Kirklees Council
Planning and Development Service
PO Box 1720
Huddersfield
HD1 9EL

Date: 15-Apr-2025
Our Ref: 2024/93431

**Application for Approval of Details Reserved by Condition
Town and Country Planning Act 1990
Planning (Listed Buildings and Conservation Areas) Act 1990**

**Discharge of details reserved by conditions 22 (BEMP), 25 (boundary treatment), 30 (retaining wall materials), 32 (external lighting), 34 (waste collection) and 35 (cycle storage) of previous permission 2022/93154 for erection of 68 dwellings with associated access, parking, open space, landscaping and infrastructure works (including installation of surface water attenuation tank)
Land at, Penistone Road, Fenay Bridge, Huddersfield, HD8 0AW
Application Number: 2024/93431**

SCALE AT A3:	DATE:	DRAWN:	CHECKED:
1:50 1:25 @ A3	28/02/25	GS	
DRAWING NO:	REVISION:		
NH/SD/S200/B/01	.

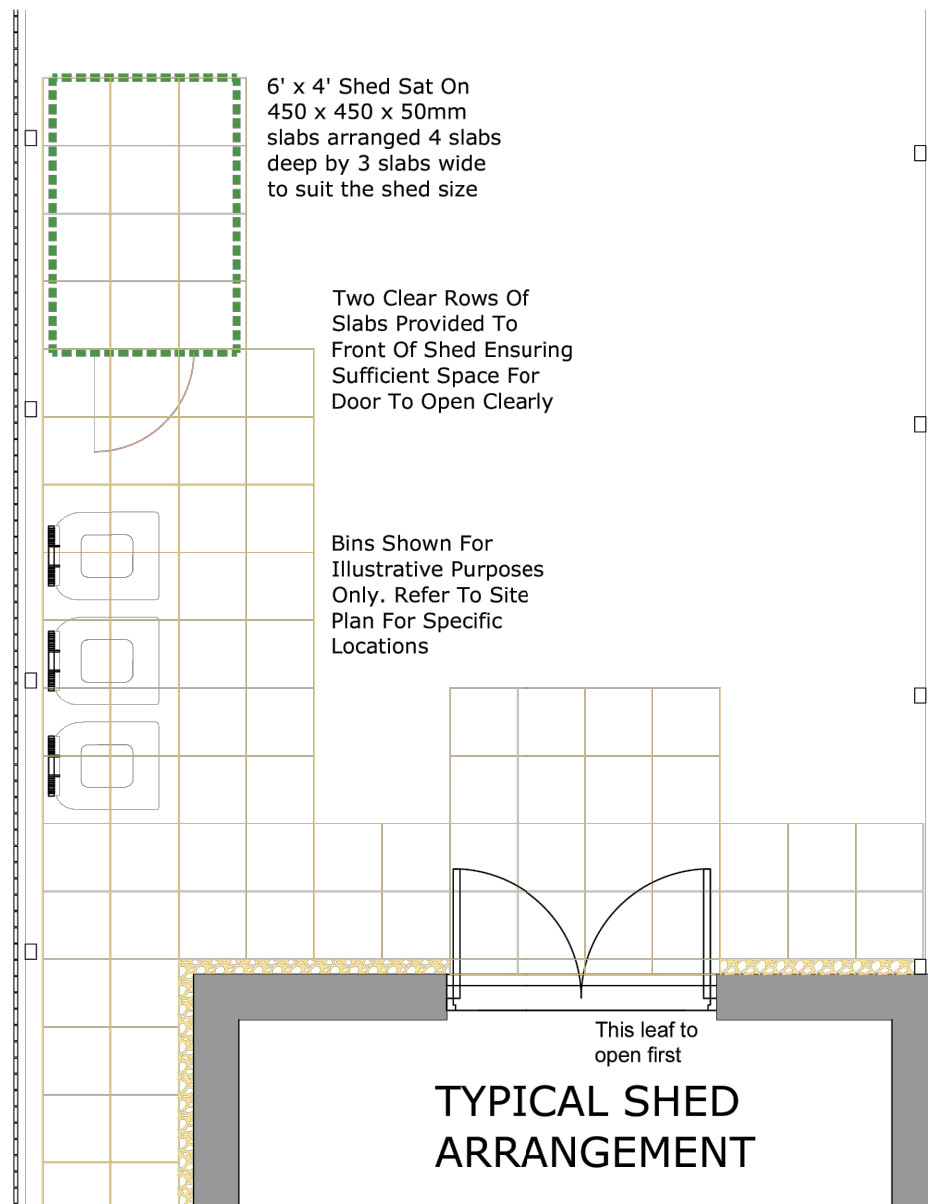
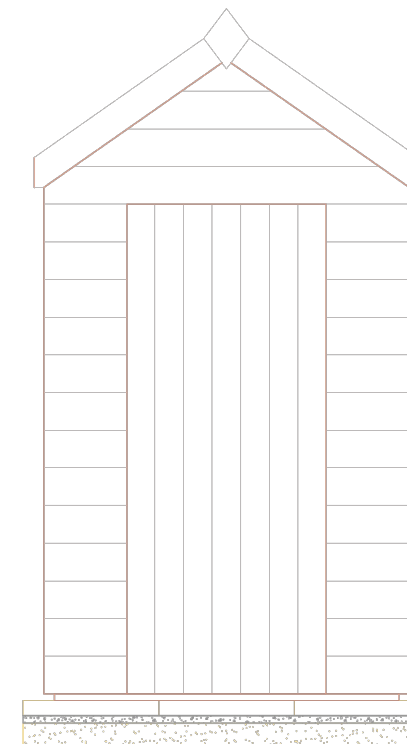
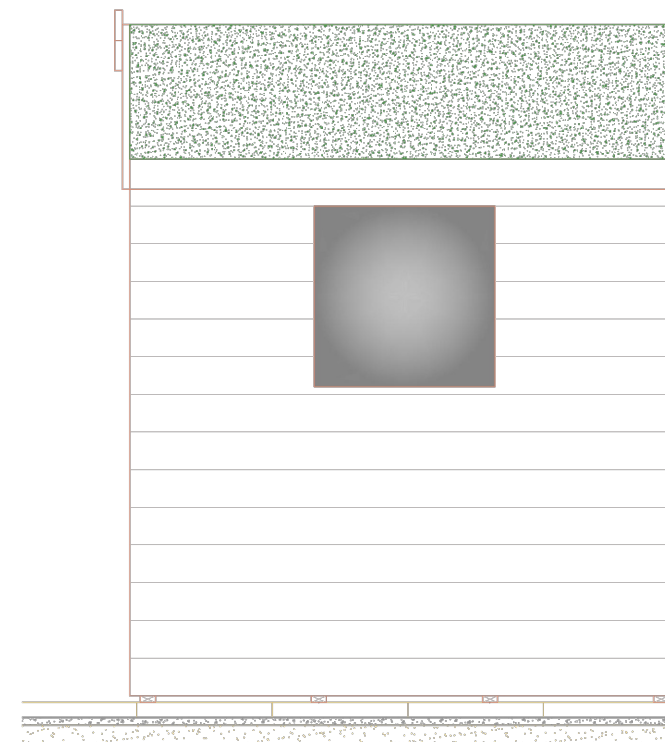
- 6x 4 Cycle Store Image
- Typical Shed Arrangement – Drawing No. NH/SD/S200/B/01, received 25/03/2025.

The above submitted information does not meet all of the requirements of Condition 35, and therefore Condition 35 cannot be discharged at this time.
